Your ref: MP 06_0143 MOD 4
Our ref: (1515900PN and 0631/08DA)

**Response to Proposed Modification MP 06_0143 MOD 4 – Glades Estate
Lots 1 and 2 DP 725785, Pacific Highway, Moonee Beach**

Bulk Earthworks and Boundary Between Zone 1 and 2

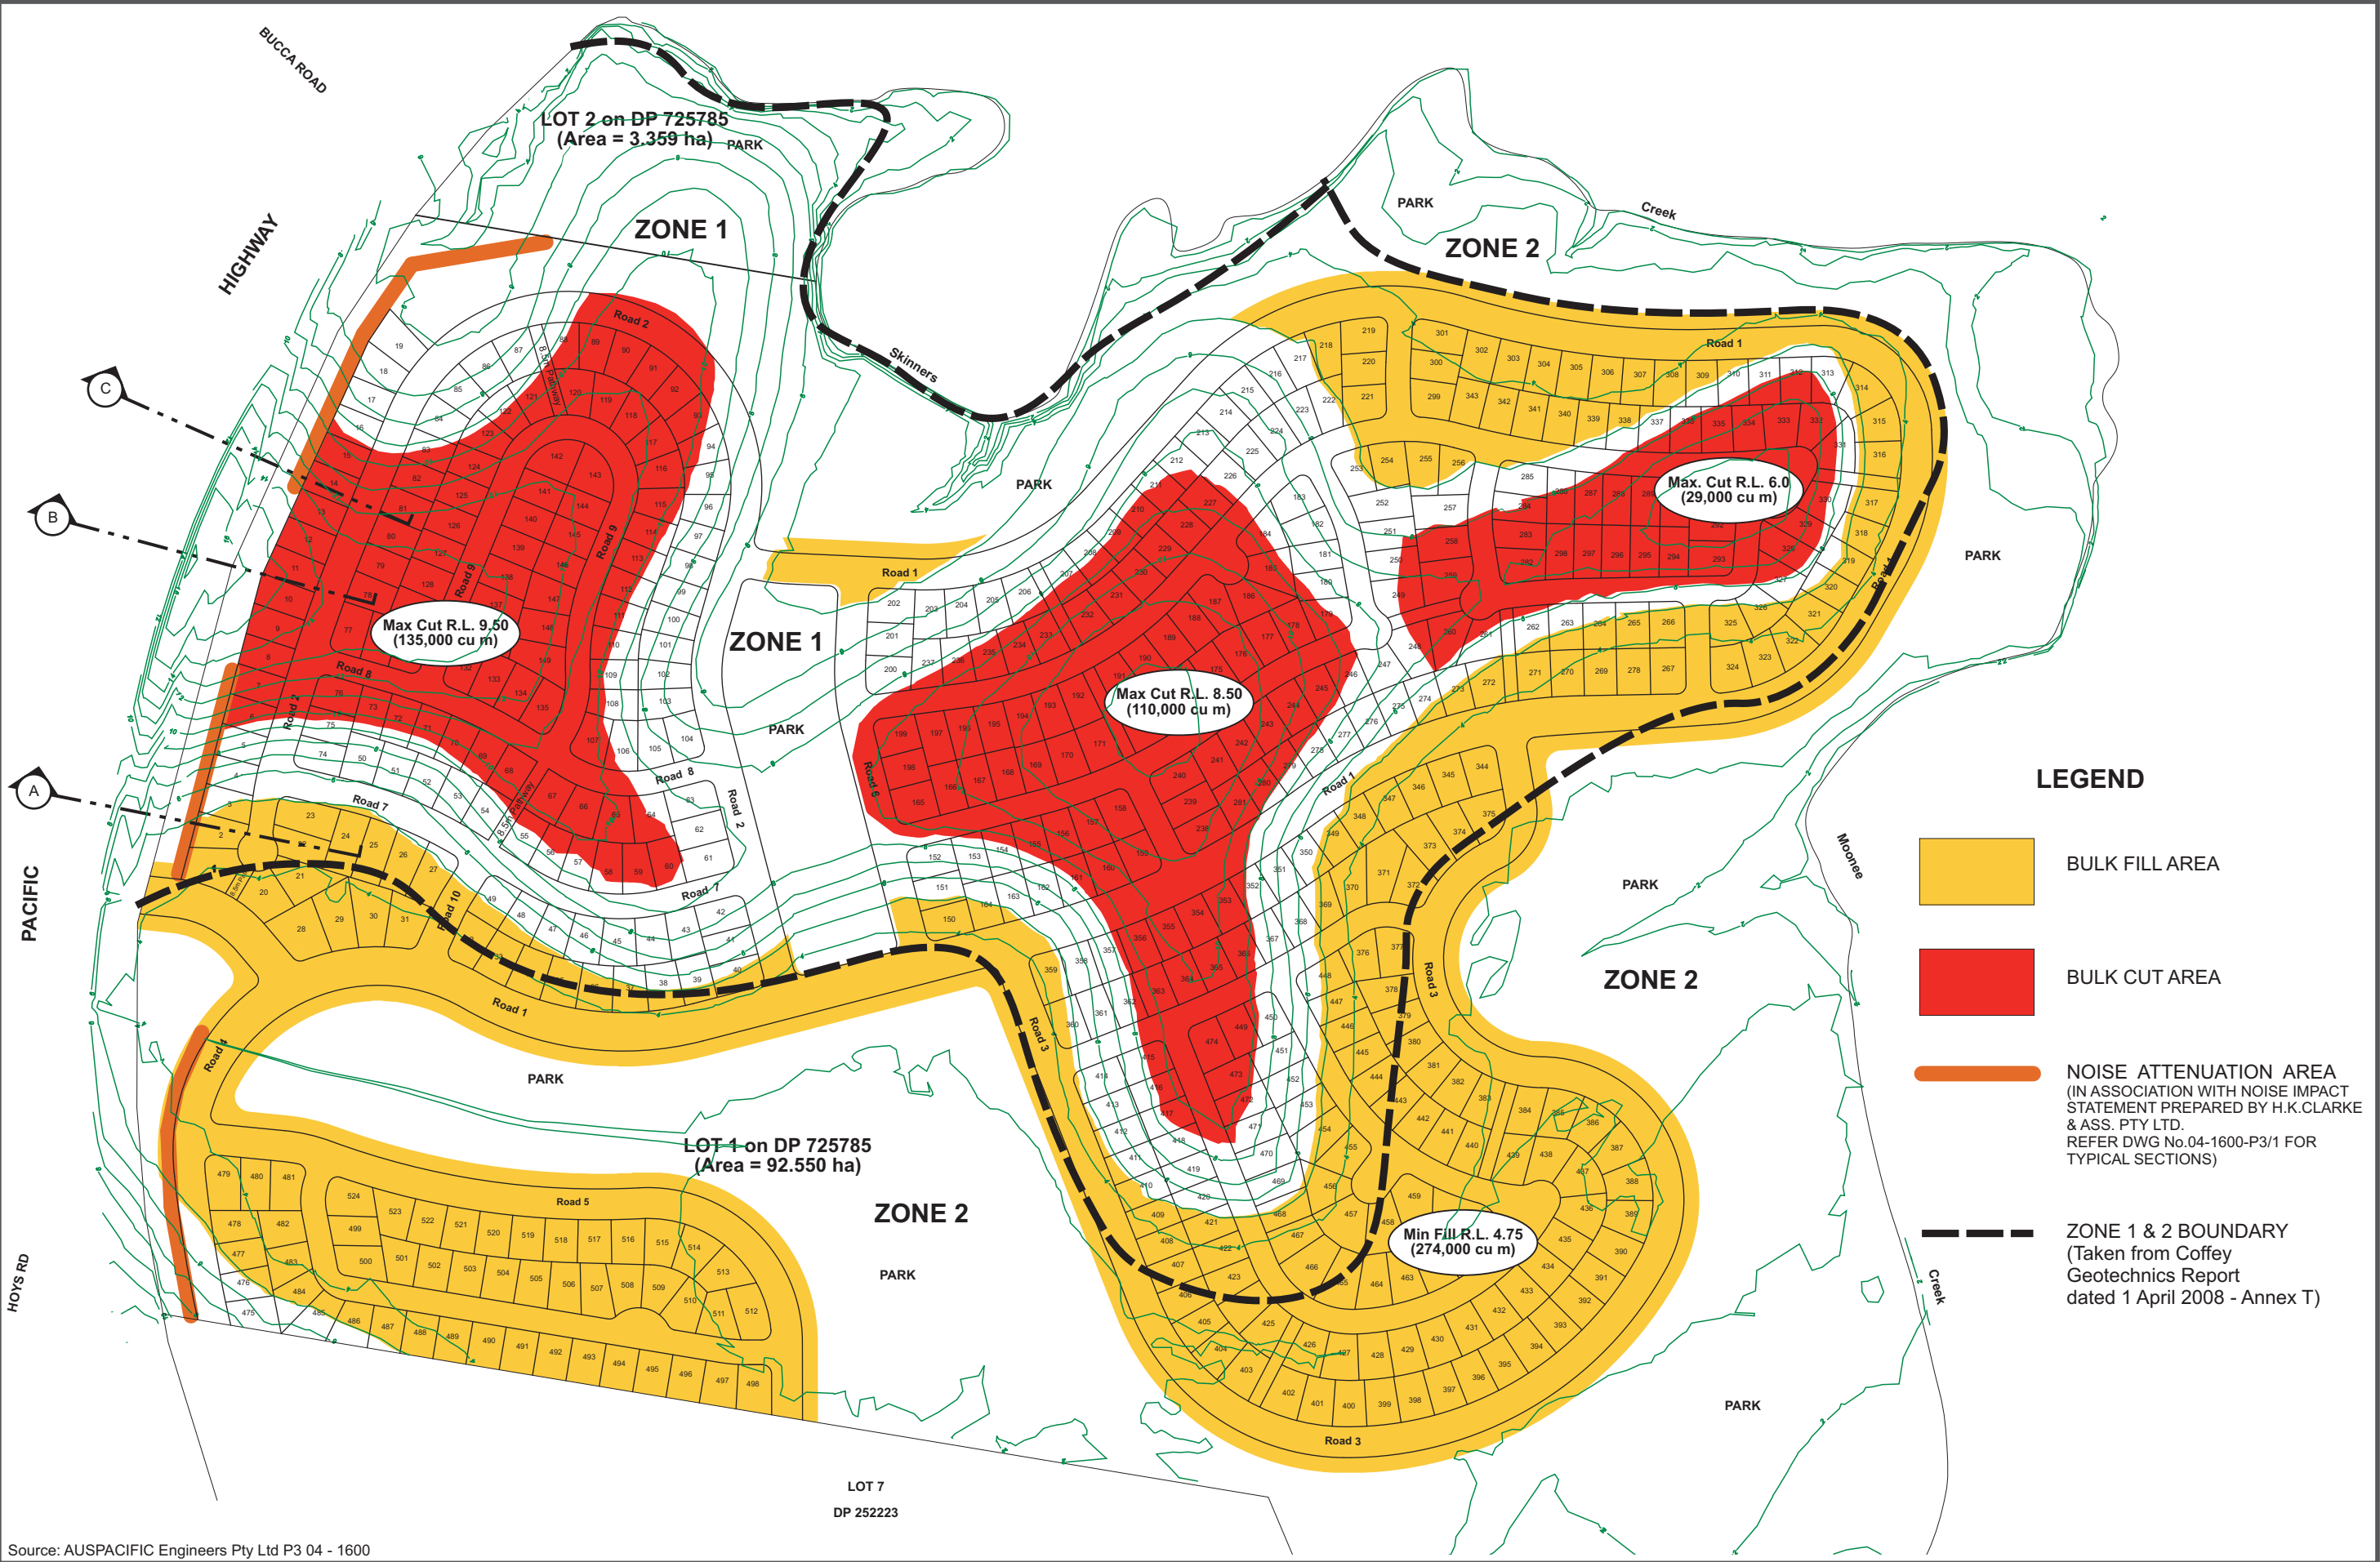
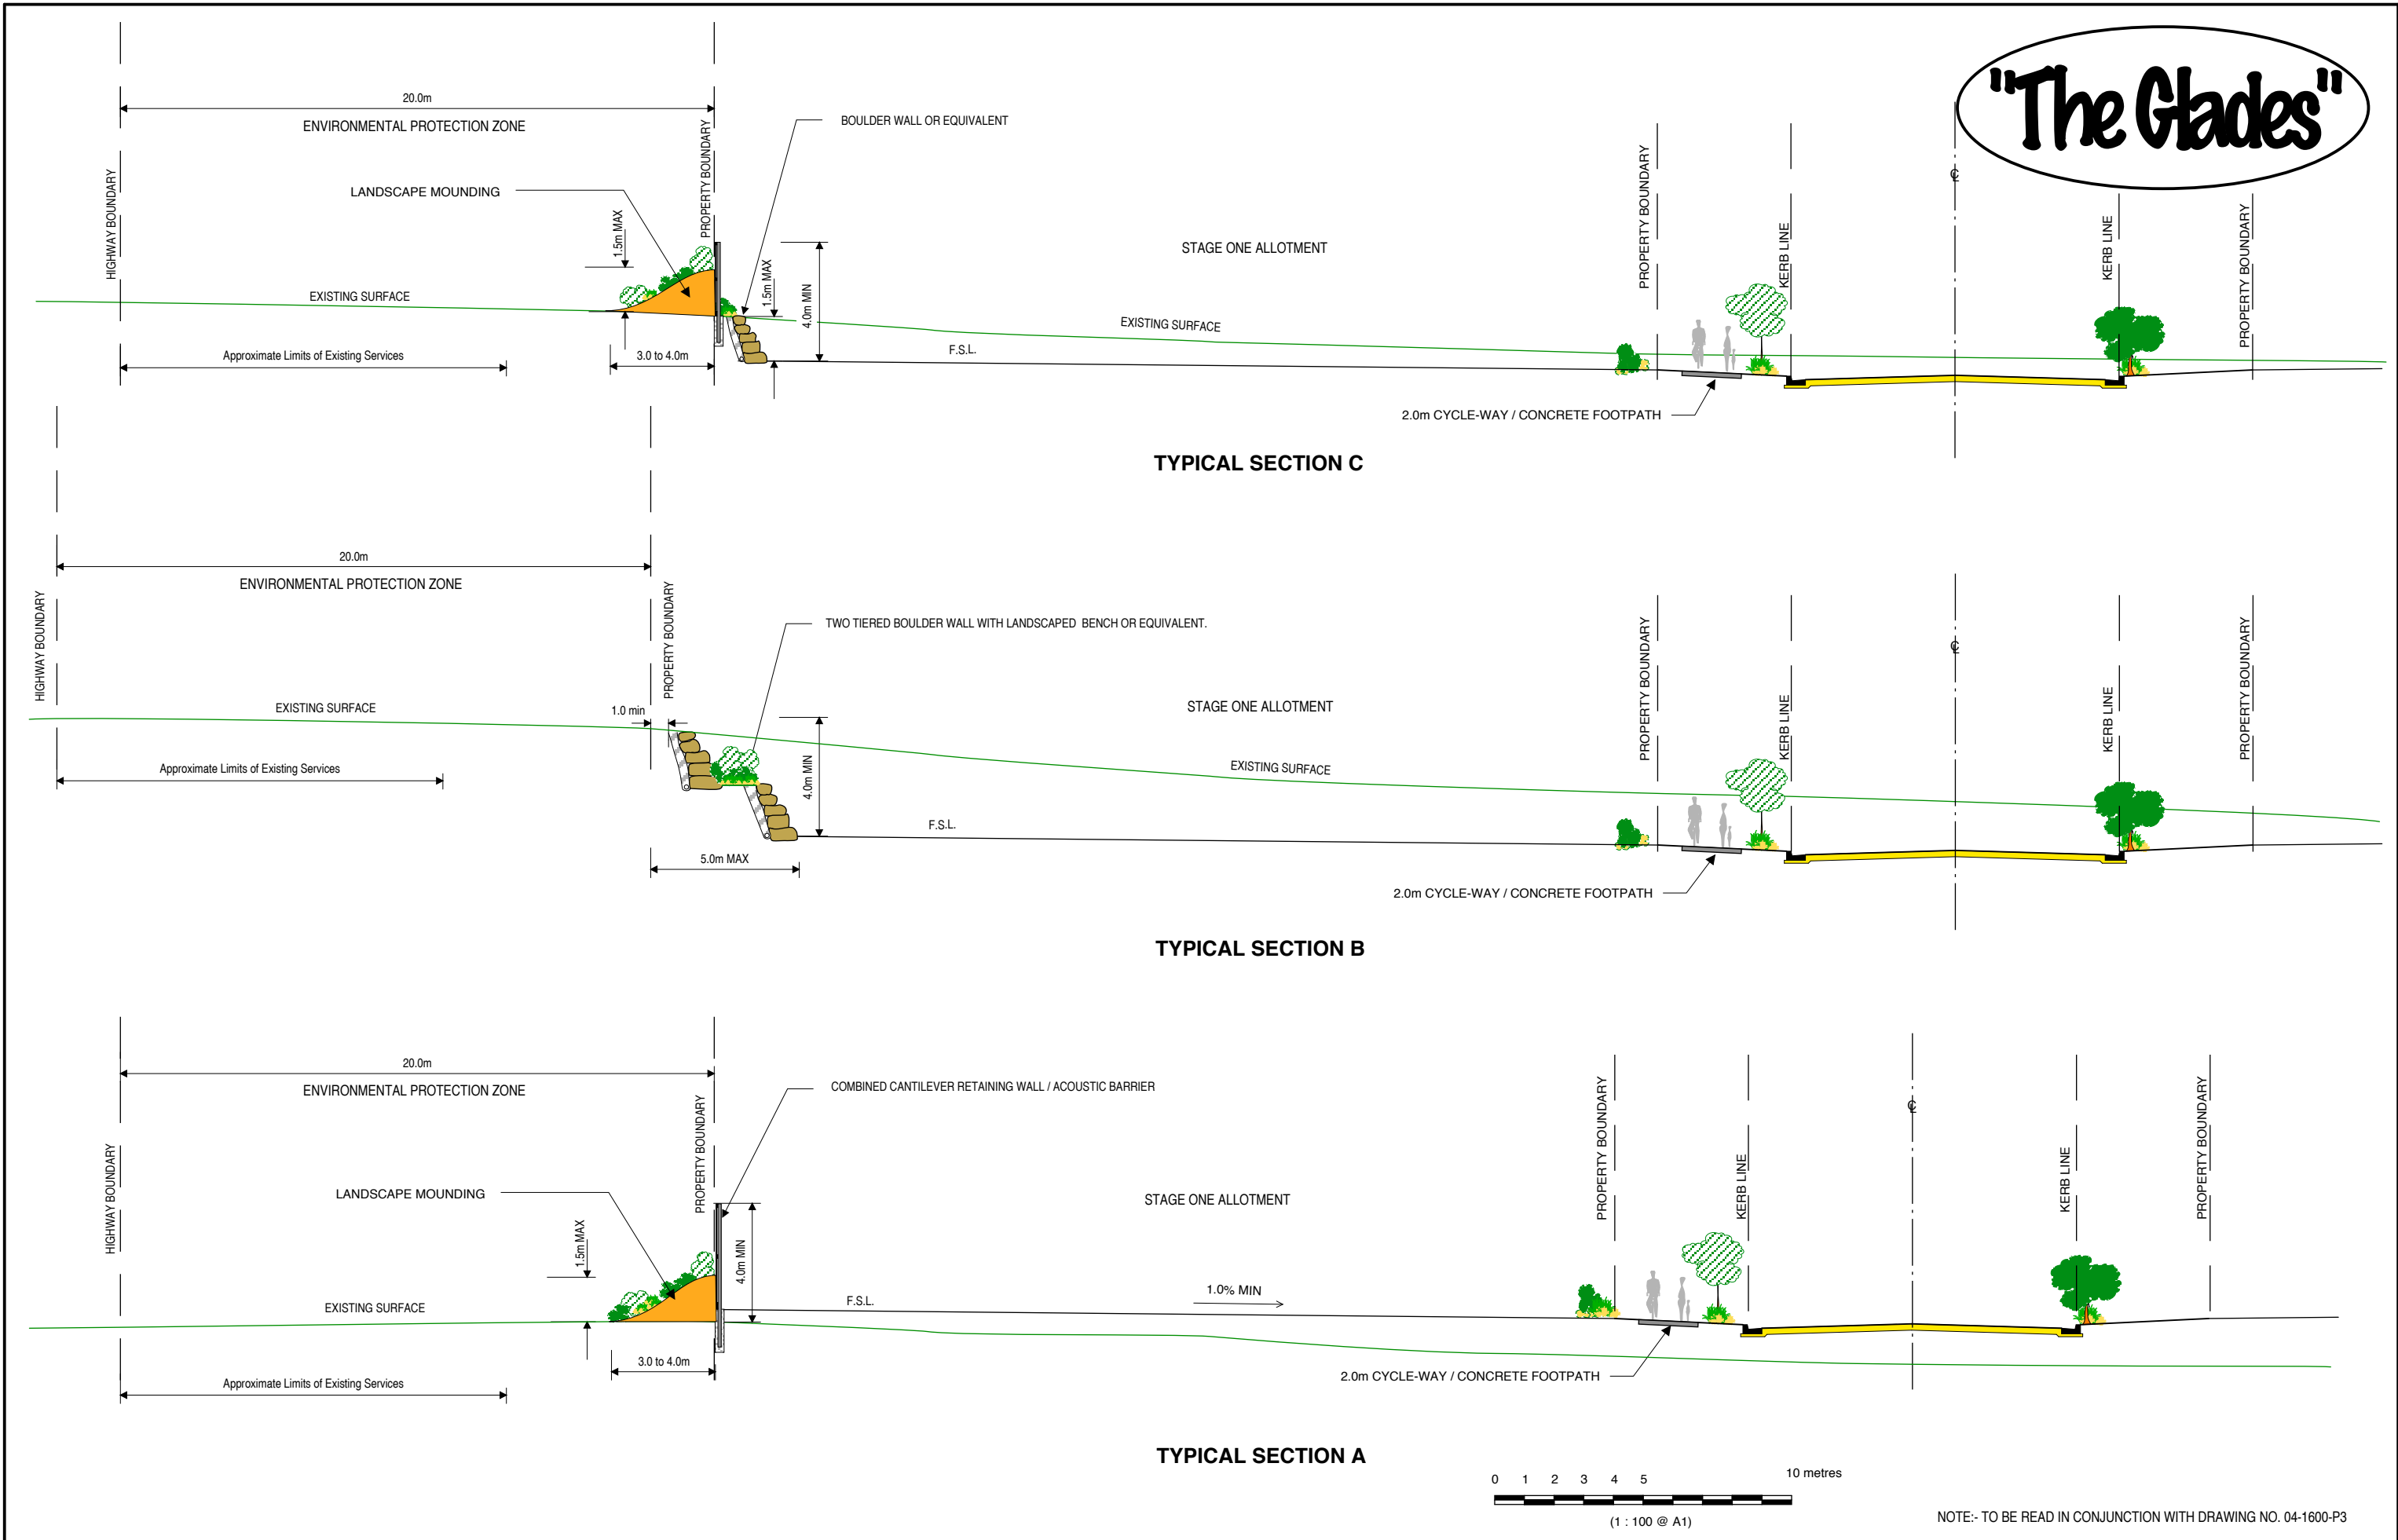
- The location of a number of the sewer pump station appears to be located in flood impacted land and below the 1% AEP flood event. Sewer pump stations are required to be located above the 1% AEP level. Council recommends that the Department ask the applicant to amend the bulk earthworks plan to address this and any associated impacts of increased fill extents (it is also noted that the designated sewer pump station and bio-retention areas appear to be conflicting. See plans referenced in Condition A3 prepared by AusPacific Engineers drawing number P5 rev. C 'Stormwater Drainage and Catchment Plan' April 2008 and P7 rev A 'Conventional Sewerage Reticulation Concept Plan' April 2008).

- Council recommends that the Department ask the applicant to provide information that satisfactorily demonstrates that the proposed bulk earthworks will not affect the feasibility for compliant design of the sewer reticulation system and stormwater network (it is anticipated that the levels and grades of critical lines would be provided to demonstrate this).

- The proposed levels around the vegetated centre corridor, whilst slightly different from the original bulk earthworks, appears to align with the existing topography on the site with the exception of the southern corridor boundary.

Council recommends that the Department ask the applicant to clarify, through cross-sections or otherwise, how the landform in this area and associated impacts (e.g. stormwater, batters adjacent road, etc.) are proposed to be managed.
